**RE: Heritage Council comments on Notice of Exhibition of SSD 6957 MOD 1–  
Crown Sydney Hotel Resort, Barangaroo South.**

I refer to your letter dated 12 June 2019 inviting comments on the Notice of Exhibition for a modification application for SSD 6957 for Crown Sydney Resort at 51a Hickson Road, Barangaroo (Lot 1221076).

Approval for SSD 6957 was granted on 28 June 2016. The proposed changes currently sought under SSD 6957 MOD 1 are largely internal with minor changes to the ground floor and several upper floors of the external façade.

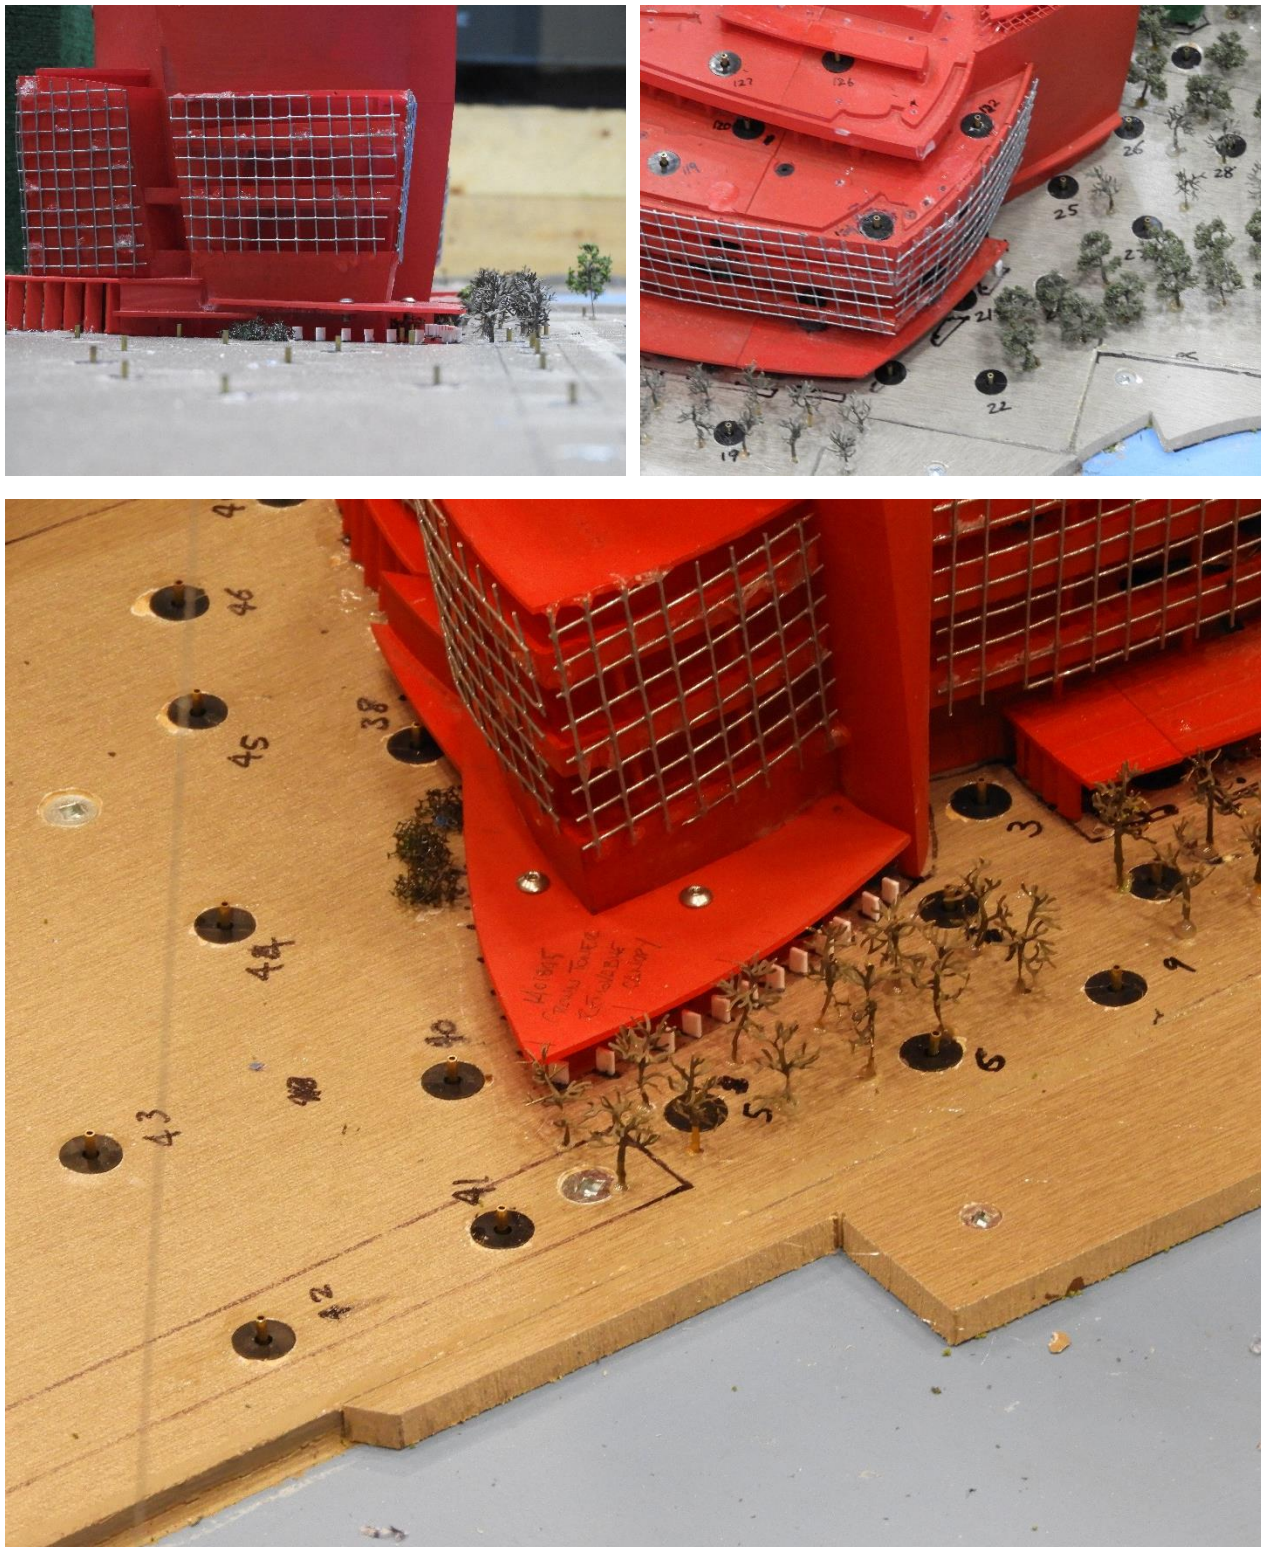
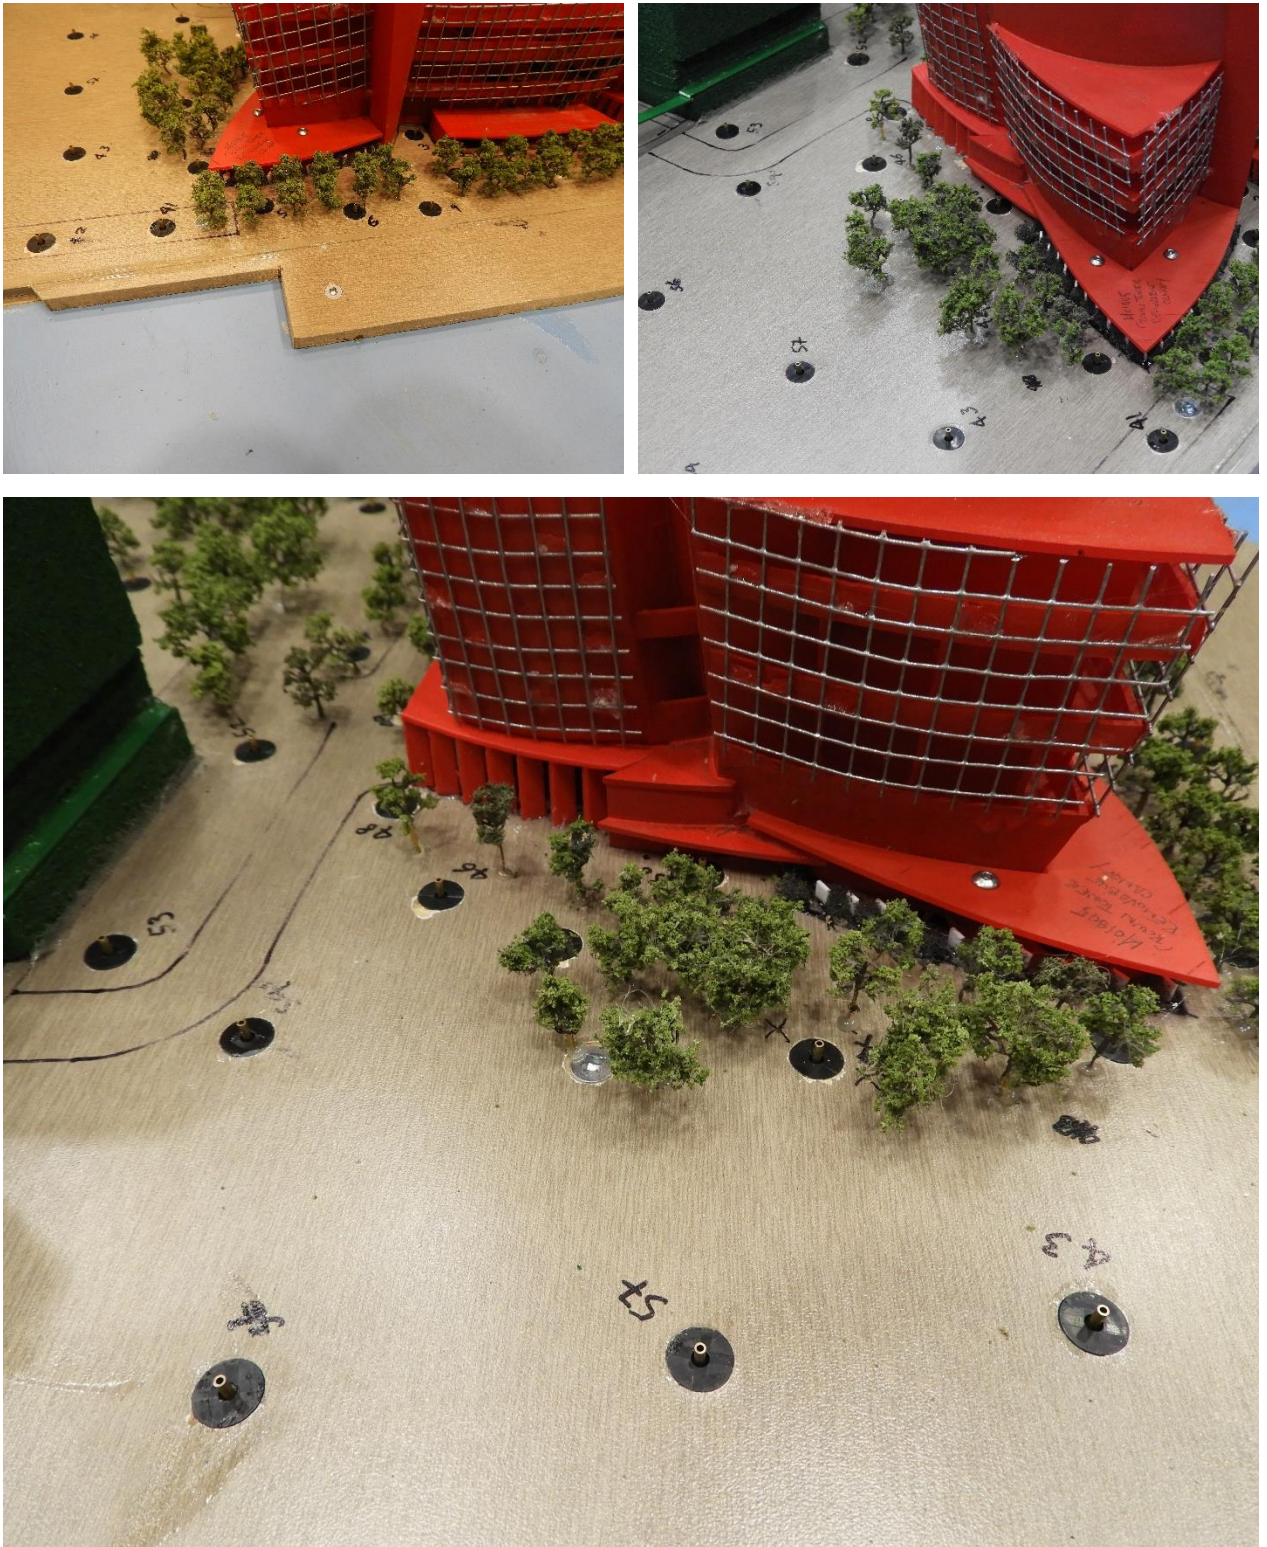
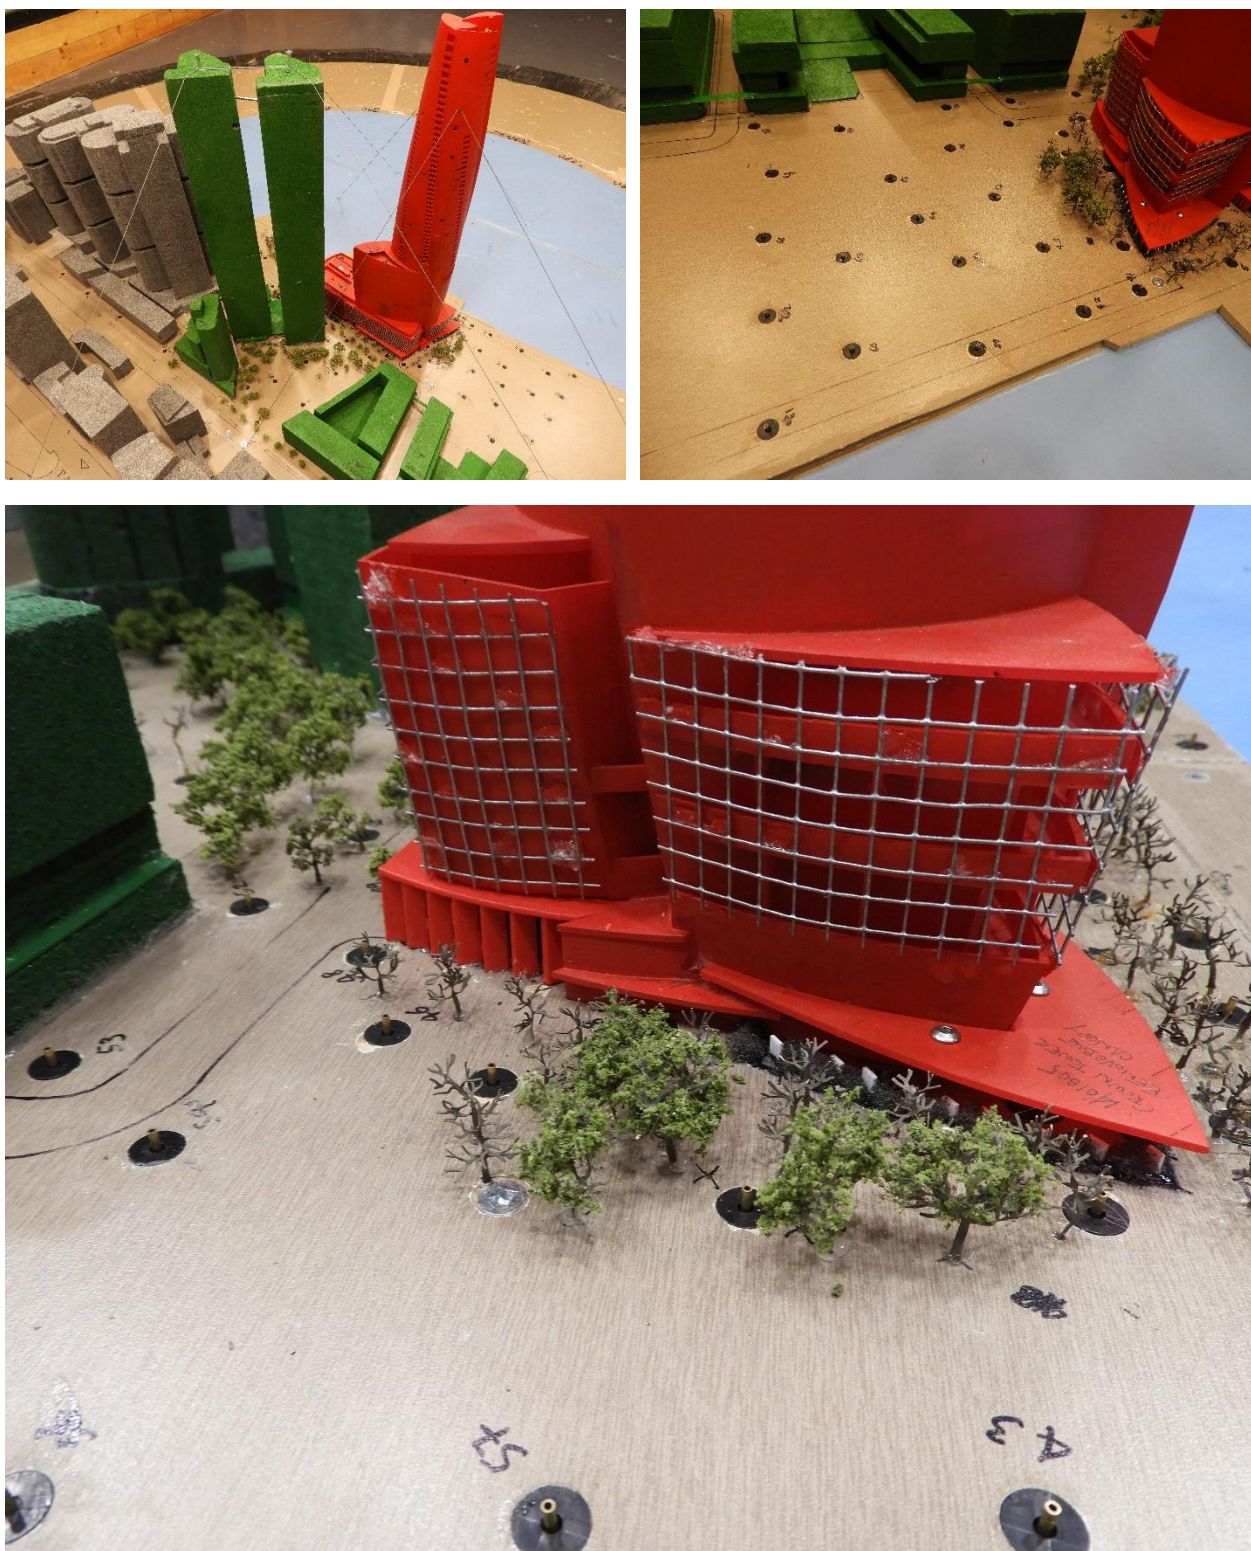
While no State Heritage Register (SHR) items are located within the subject site, the new hotel building lies in close proximity to Millers Point. The main heritage impacts identified in previous Heritage Council comments relate to the size, scale, bulk and visual intrusion of the new buildings and their impact on significant views into and out of Millers Point.

The impact of the proposed external changes is minor and, as a consequence, there is no change to the adverse heritage impact of the new buildings (size, scale, bulk and visual intrusion) and the impact on significant views into and out of Millers Point.
